Response to Planning application from Hertfordshire County Council (T and CP GDP Order 2015)

District ref: 6/2023/1124/FULL
HCC ref: WH/17057/2023
HCC received: 8 June 2023
Area manager: Manjinder Sehmi
Case officer: Senober Khan

2 Hill Rise Cuffley Potters Bar EN6 4EE

Erection of 5 bedroom dwelling following the demolition of existing dwelling

Site Plan 1:200 Scale

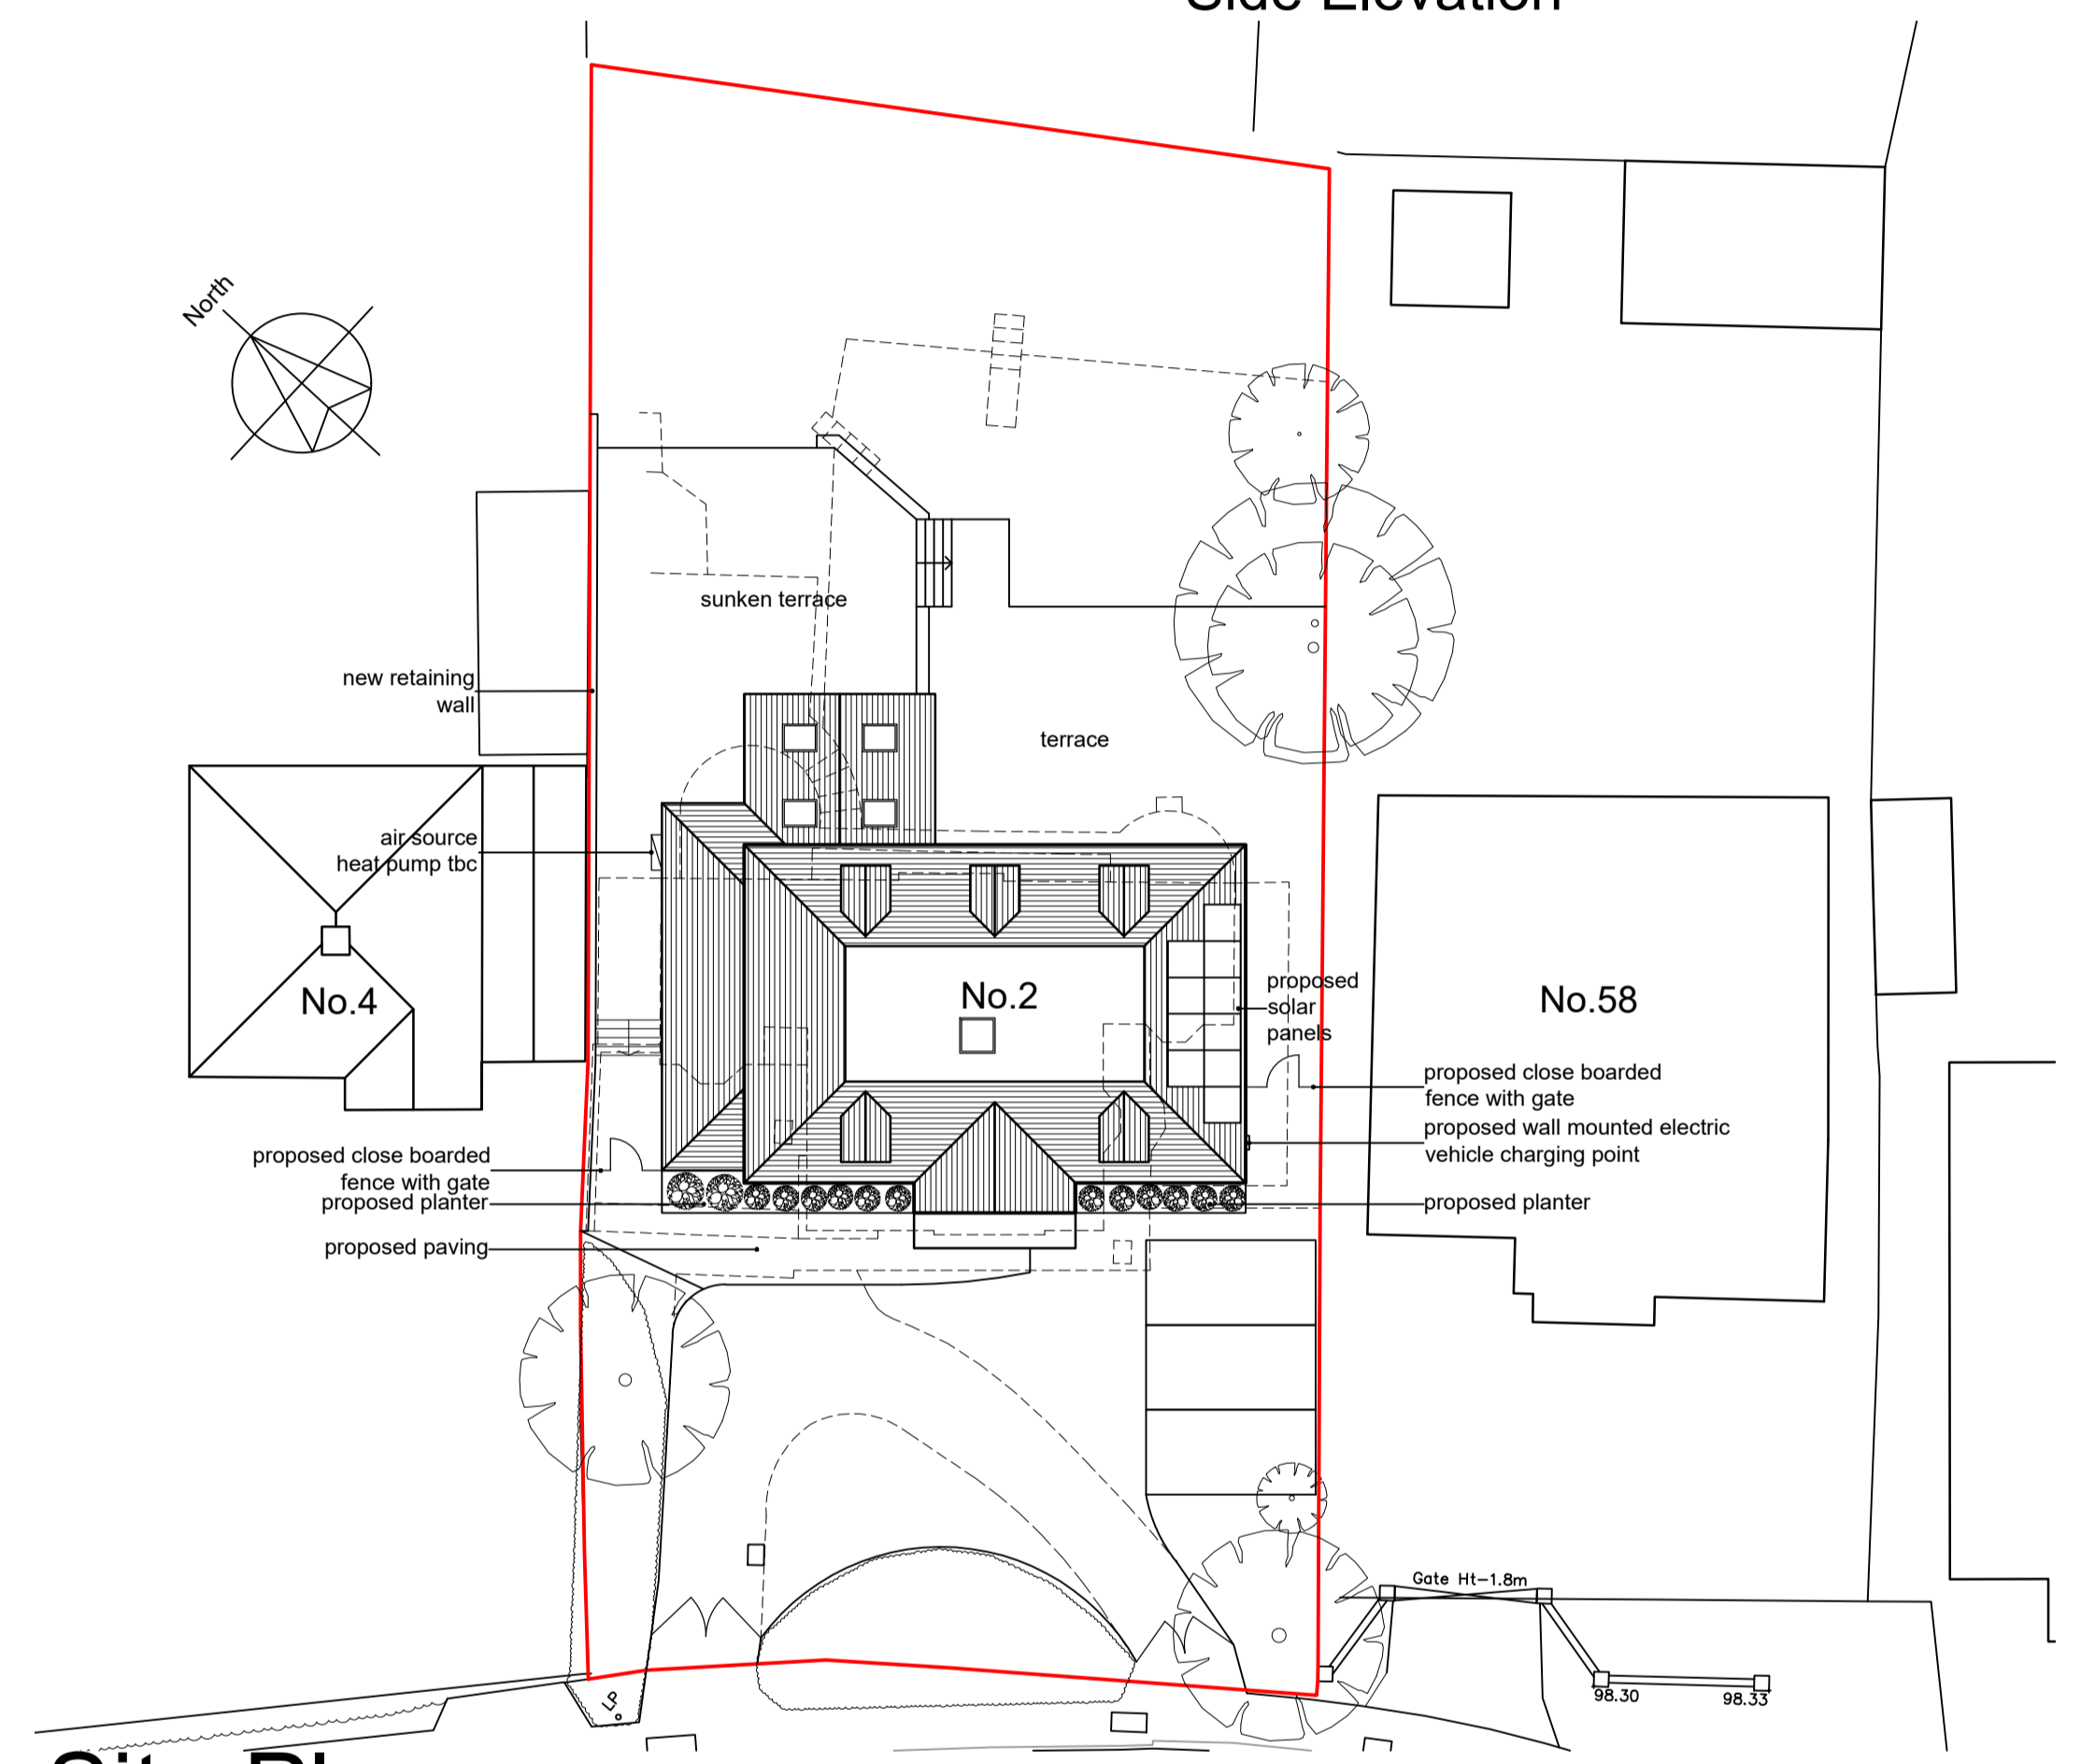
The application has failed to demonstrate and substantiate a satisfactory design-led approach to the development's vehicle access design and layout.

The proposed use of the existing northern vehicle access sited opposite The Driveway junction with Hill Rise for the new build continues with past obsolete standards which are prejudicial to the highway safety of all road users, contrary to current higher standards of design and safety.

The application has failed to demonstrate a satisfactory policy and design-led approach to the provision of pedestrian visibility splay and the installation of gate which are prejudicial to the highway safety of pedestrians.

No cycle parking/storage has been shown, Cycle parking provision and storage for the new dwelling should be compliant with policies.

The applicant has shown 2 vehicle accesses each with gate, but no pedestrian visibility splays, furthermore the northern vehicle access is opposite an existing road 'The Driveway' creating a crossroad, and no cycle parking provision has been shown.

Under the proposals the proposed use of the existing northern vehicle access which is opposite 'The Driveway' would result in the continuation of a crossroad for a new build development, this is not acceptable under current guidance's and policies for new developments.

In order to minimise conflict points and to prevent them from exacerbating such conditions is why guidance's advice vehicle accesses should be located away from junctions such as The Driveway. Parking restrictions/double yellow lines are installed at all junctions including at this junction The Driveway/Hill Rise, to prevent parking on the highway and any vehicle crossovers, therefore guidance/practice recommend that depending on the highway conditions vehicle accesses should not be located within 10/15m from a junction. The HA would not support any dropped kerb/vehicle access within the double yellow markings at junctions.

Local Highway Authorities (LHA's) do not support second vehicle access/dropped kerbs serving a single dwelling/development. This is because more than one, in particular unjustified, vehicle accesses serving a development create more potential conflict points between pedestrians and vehicles and vehicles with vehicles, reduces the amount of safe footway for pedestrians to walk along due to more crossovers, it would also set a precedent for other developments to apply for more than one vehicle access exacerbating the conditions. (see the following Council guidance: <https://www.hertfordshire.gov.uk/services/Highways-roads-and-pavements/Changes-to-your-road/Dropped-kerbs/Dropped-kerbs.aspx#Second%20Dropped%20Kerb>)

For pedestrian safety reasons it is necessary to maintain within the site areas measuring 2m by 2m, with no obstruction more than 0.6m high, either side of where the vehicle access meets the back edge of the footway, known as pedestrian visibility splays, within which unobstructed visibility is available for drivers to see and be seen by pedestrians on a footway to avoid a potential hazard in time. The splays must be wholly within the site's curtilage and physically protected (dwarf wall/ped gate) from being driven over thereby undermining their necessity.

LHA's do not support gates/barriers at vehicle accesses in close proximity to the public highway due to the obstruction caused by a standing vehicle at the entrance to both pedestrians and vehicle traffic

flow while the gates are opened/refused access. Alternatively, gate facilities provided on residential premises, they shall be sited at least 6m from the highway boundary or back of footway as appropriate. This is to avoid waiting vehicles obstructing traffic and pedestrians on the road and footway passing the site. This may be reduced to 5.5m if the gates or doors open inwards or are in the form of a roller.

The applicant has not shown any cycle parking for the new dwelling. For the proposal to satisfy Local Plans and Residential Design Guides, cycle parking provision including the layout and design, should be in accordance with the Welwyn Hatfield District Plan. The provision of adequate cycle parking that meets the needs of occupiers of the proposed development is in the interests of encouraging the use of sustainable modes of transport in accordance with the Local Transport Plan.

The applicant has not shown EV charging provision for the new dwelling. The County Council sets out its support of EV infrastructure within its' Local Transport Plan (2018) noting that this can reduce vehicle emissions and gives support to government and private sector led efforts to increase adoption of ULEV technology (Policy 20) and ensuring parking provision in new developments provides facilities for electric charging of vehicles (Policy 5).
